**Consultation Response from KC,  
Highways Development Management**

**2023/91260 444A, Huddersfield Road, Ravensthorpe, Dewsbury, WF13 3EP**

**Erection of two storey rear extension to existing commercial premises, raising of roof height and erection of front and rear dormers and alterations to form 8 unit HMO**

**Date Responded: 1-8-2023.**

PROPOSED GROUND FLOOR PLAN 1:50

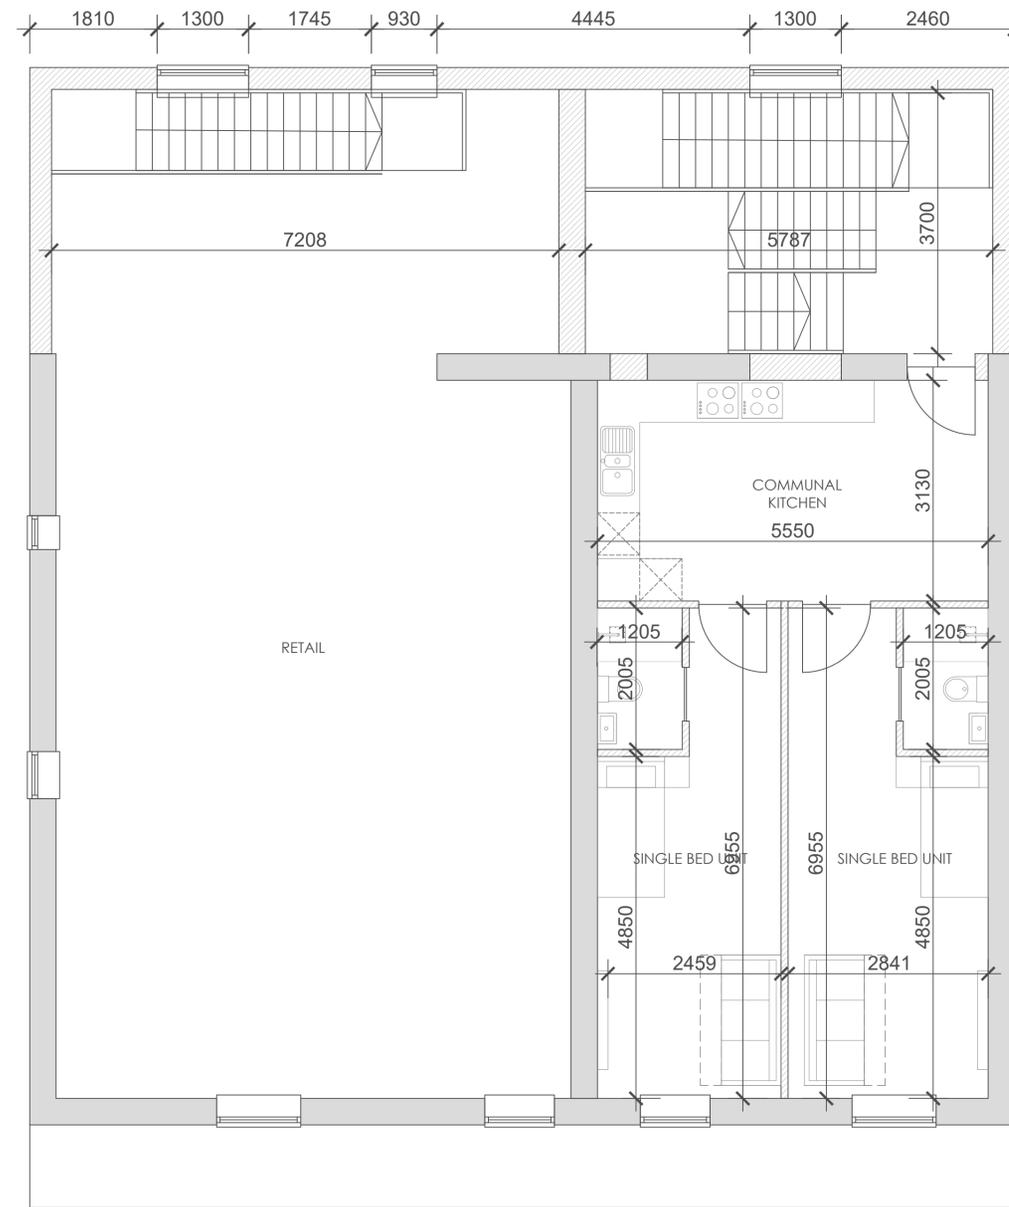
There is a service yard to the rear of the premises for the retail and hot food use.

This application provides insufficient information.

Can the applicants provide details of their proposals for the storage and collection of wastes from the site.
